Subject: RE: Saltbox Unit 9 site Planning Condition 12 response Surface water

Paul Cann
Principal Drainage Engineer
Engineering Services

2. Specify gully lateral gradients/outlet & inlet levels. ie. those that connect to manholes S1 and S3. Laterals to be 150mm diameter laid at 1/150 to keep connection levels as high as possible. Gully lateral gradients and inlet levels shown – unable to lay at 1 in 150 to raise S1 due to very minimal cover which would potentially cause hard spots within the car park construction where cover is less than the asphalt construction depth. Now ok

C	5.04.22	MR	Add Inlet Connections
B	17.03.22	MR	Amend Overlay View
A	4.03.22	MR	Amend Layout & Volume
-	19.01.22	MR	Sales Drawing

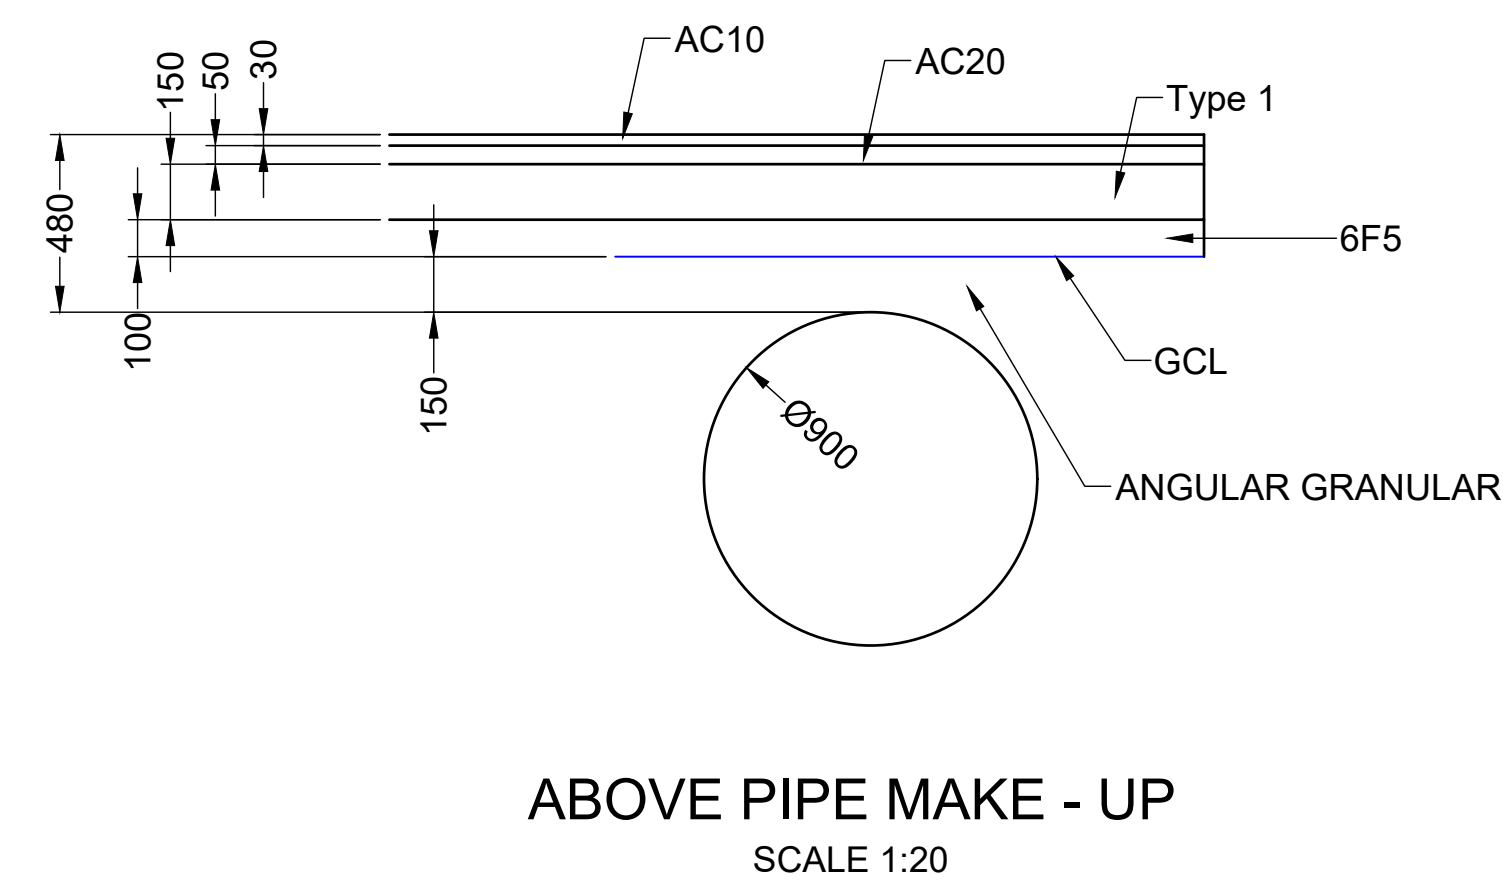
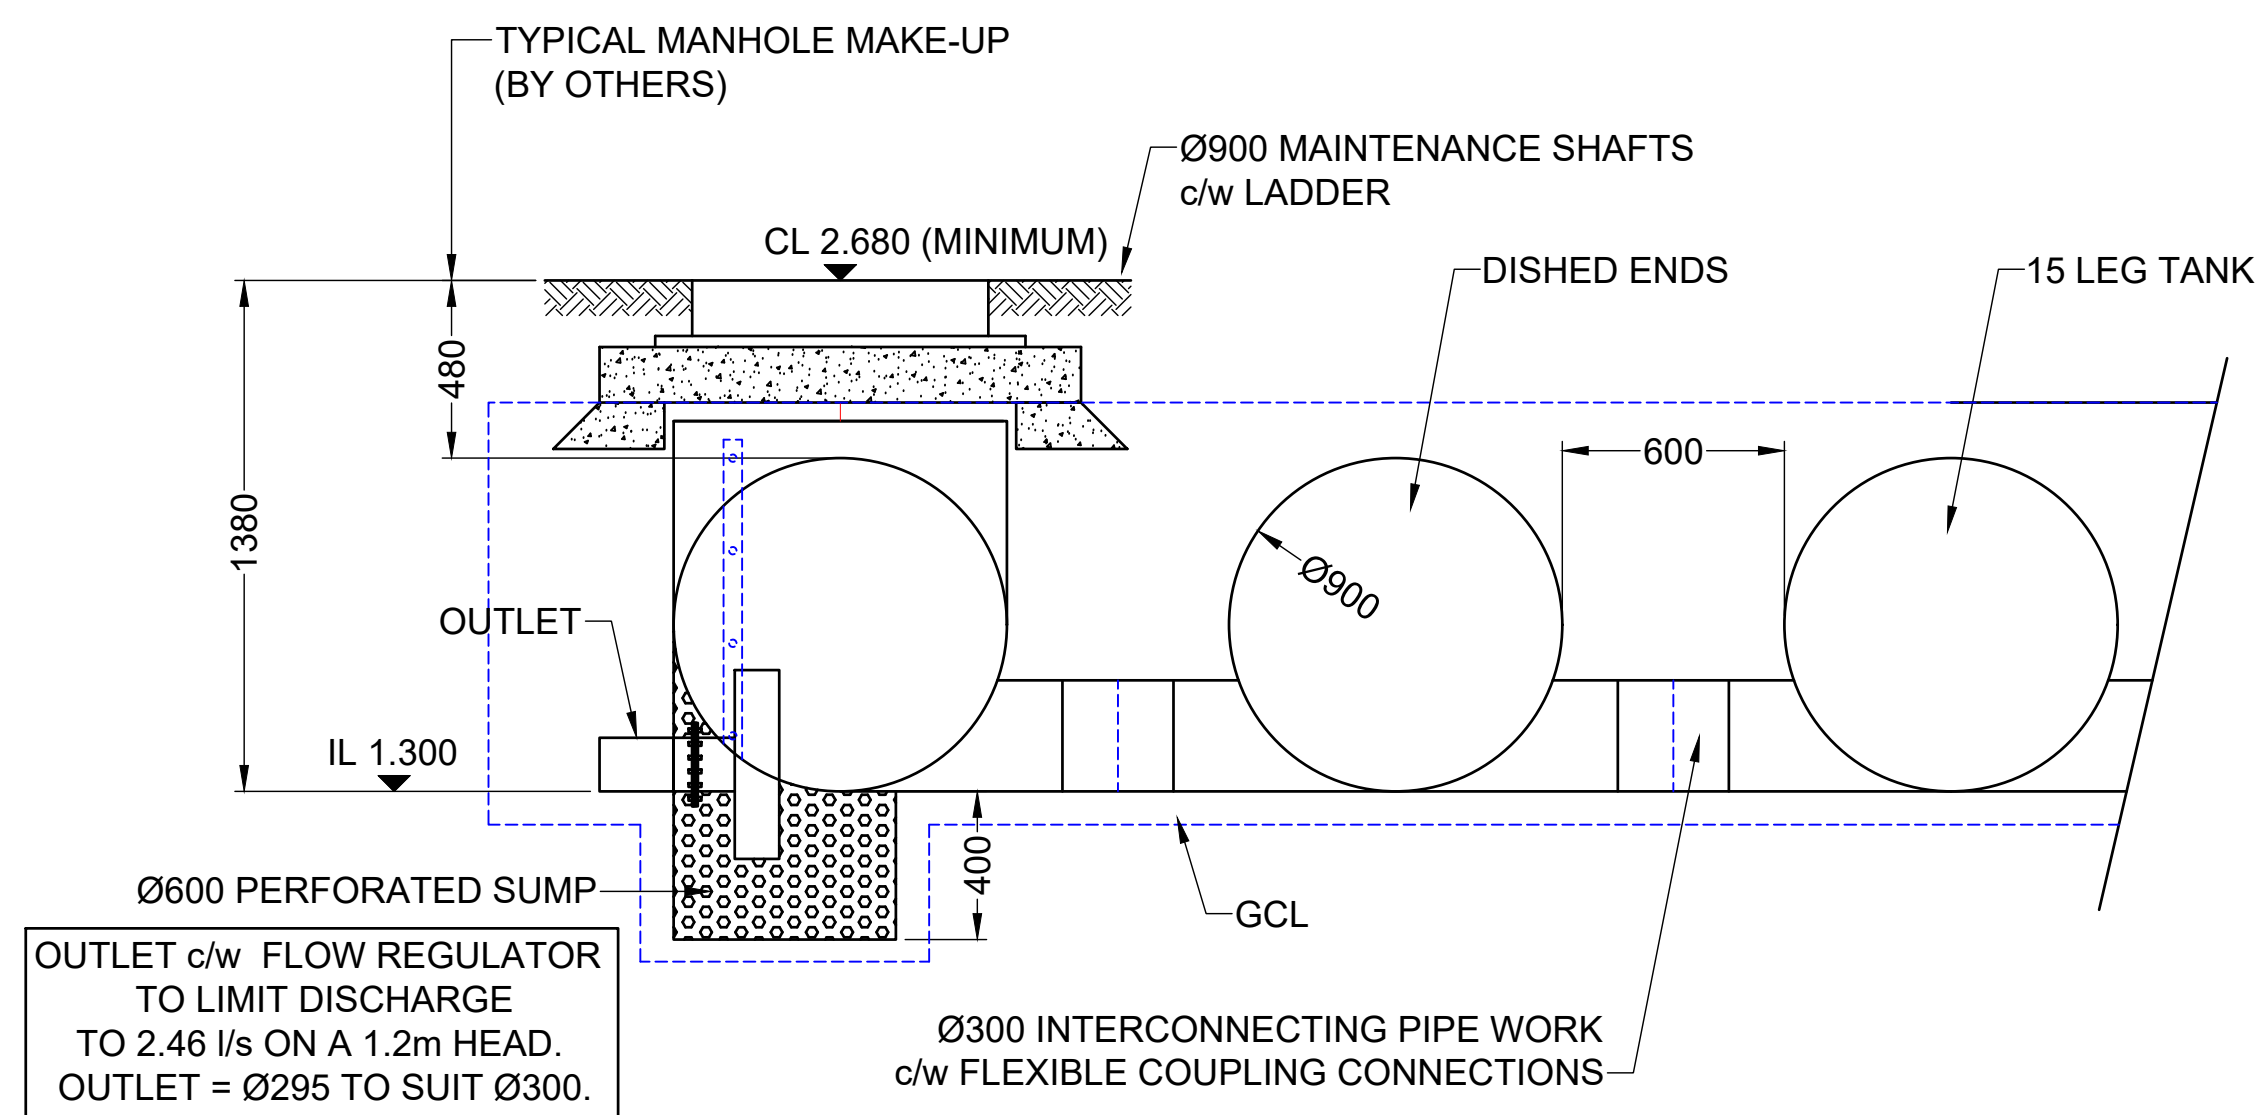
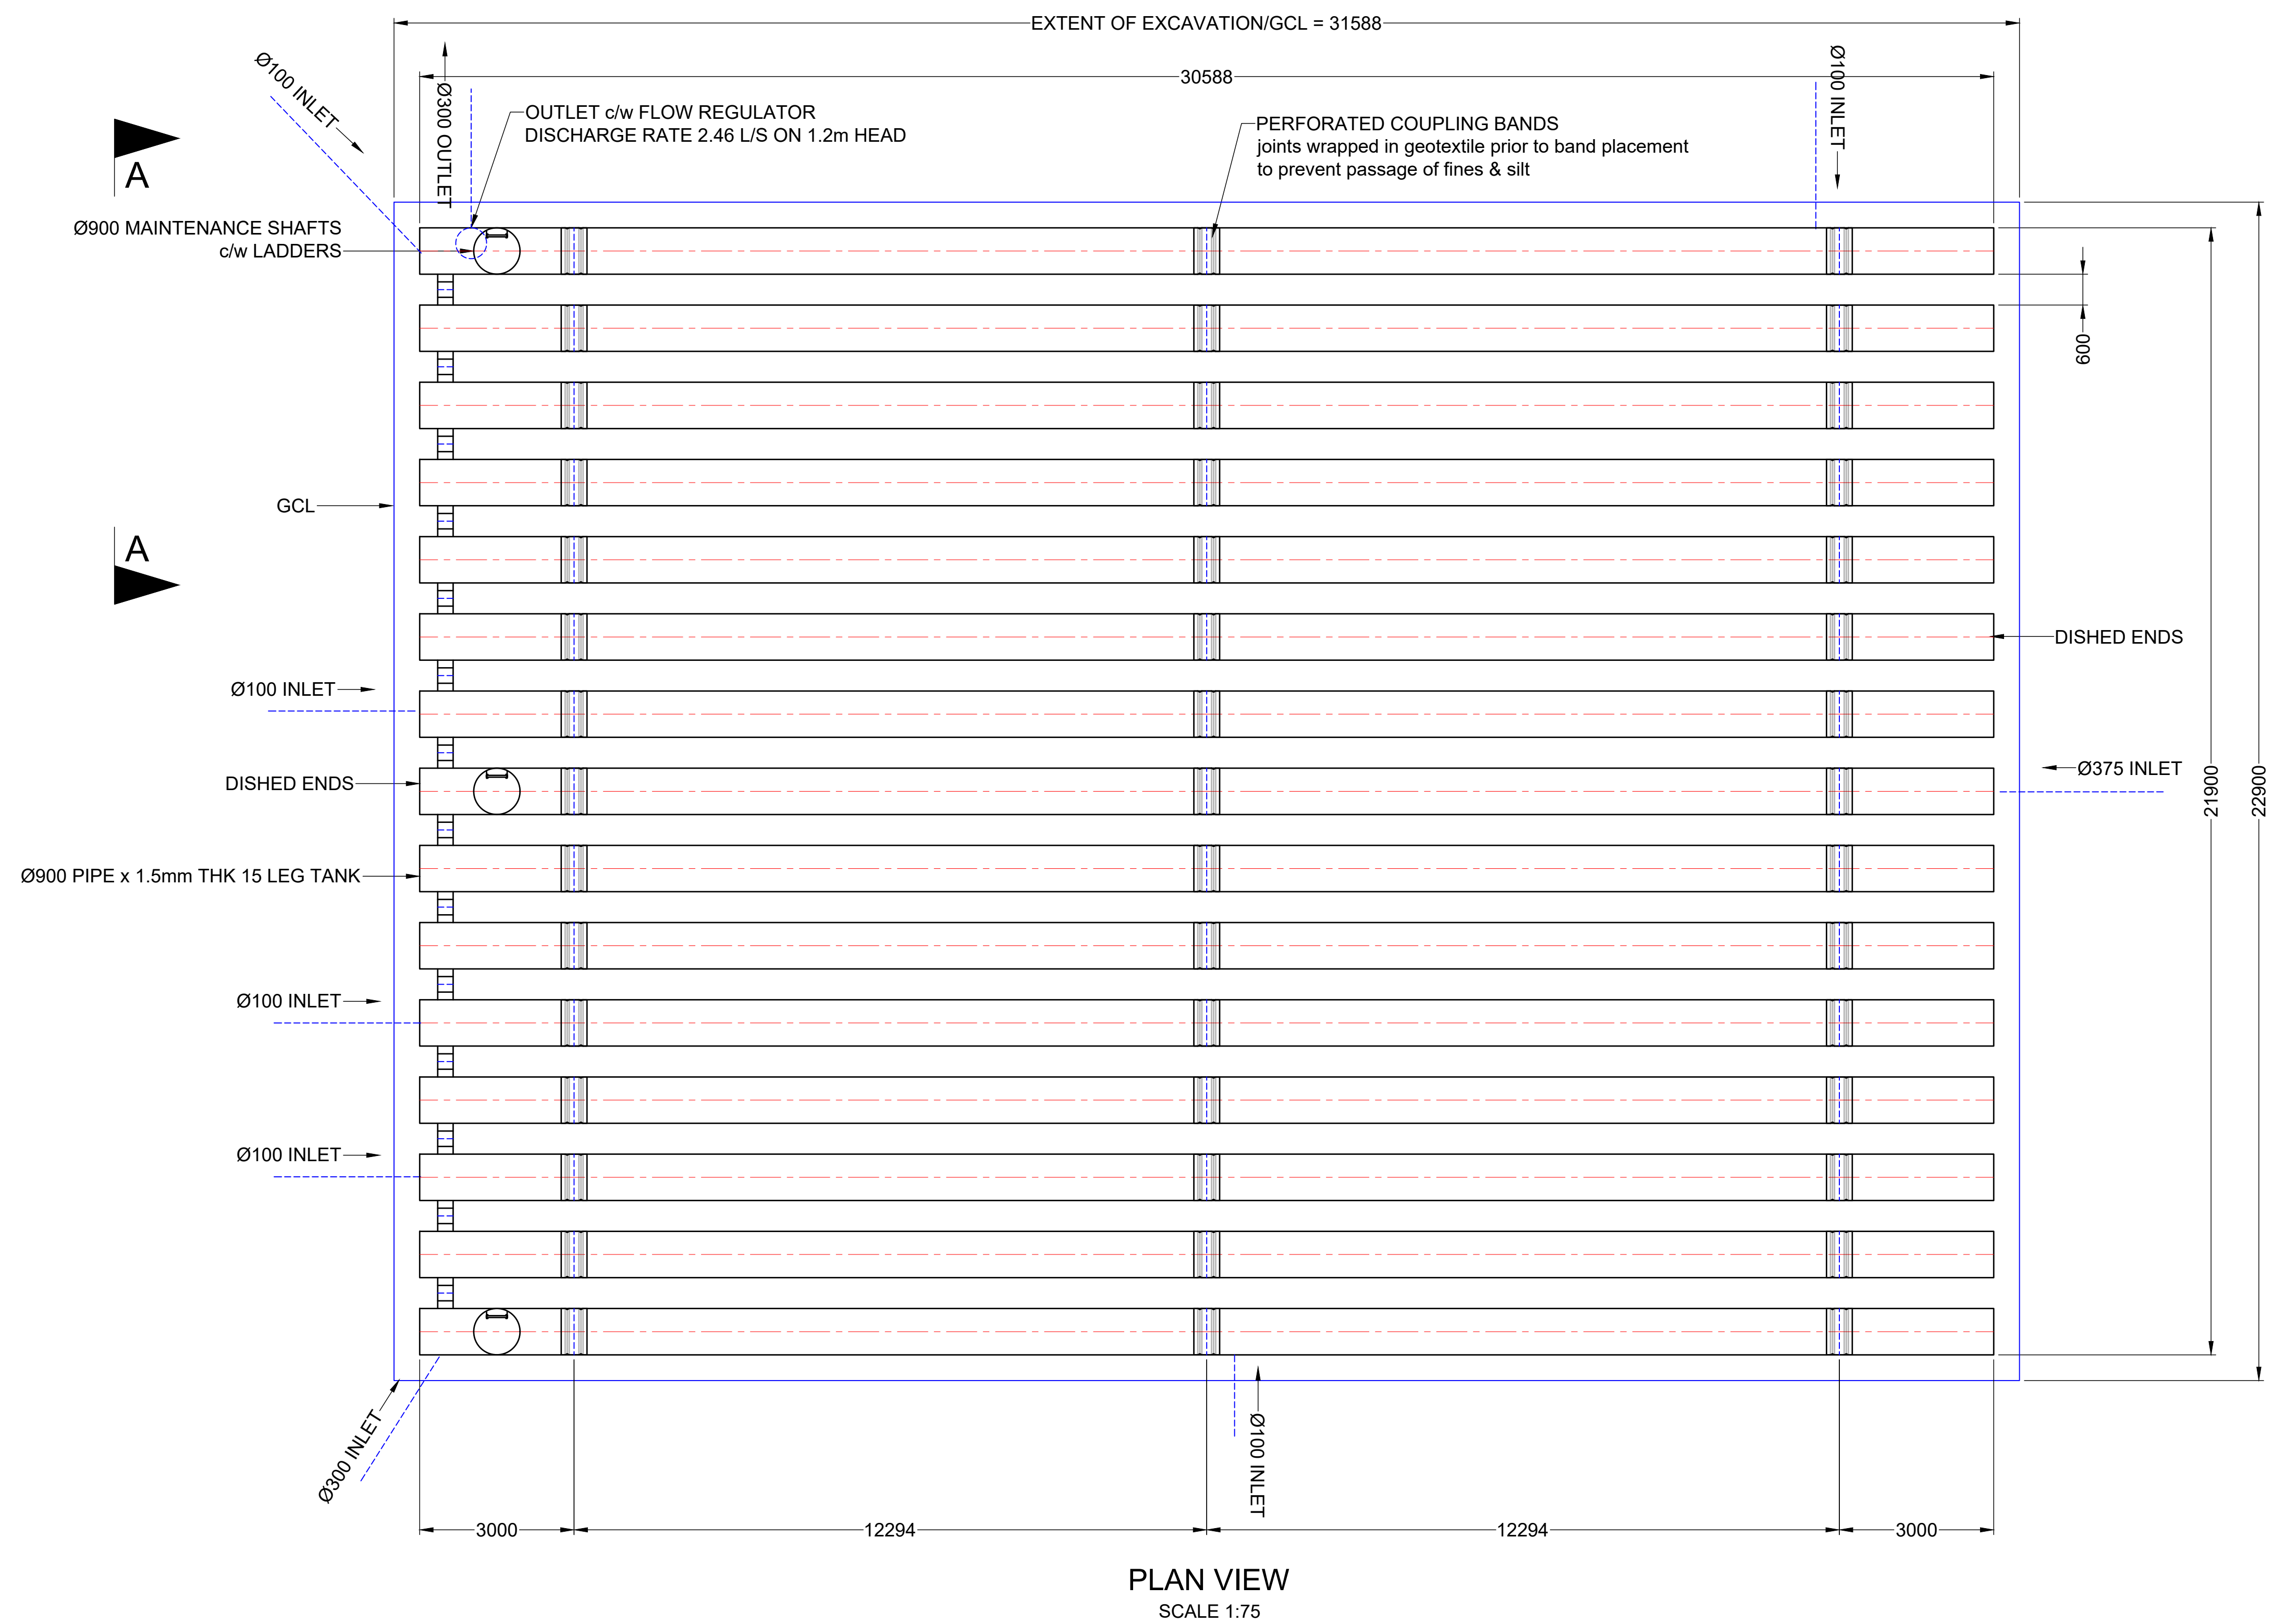
29. Provide fully detailed construction details for Tubosider attenuation tank including integral chambers/flow control chamber. Tubosider details attached. Your layout plan indicates 4 no. access chambers whilst theirs has 3 no. Clearly indicate 300mm diameter link pipe locations on layout plan. Fully detail make up above the prefabricated access chambers ie. class D400 covers, engineering brickwork, concrete slab spec & dims, etc. Include ladder access as a requirement rather than an option. Not sure why the hydrobrake sump is perforated, please advise/provide more detail. Please adjust detail to suit the 300mm outfall pipe discussed in item 17.
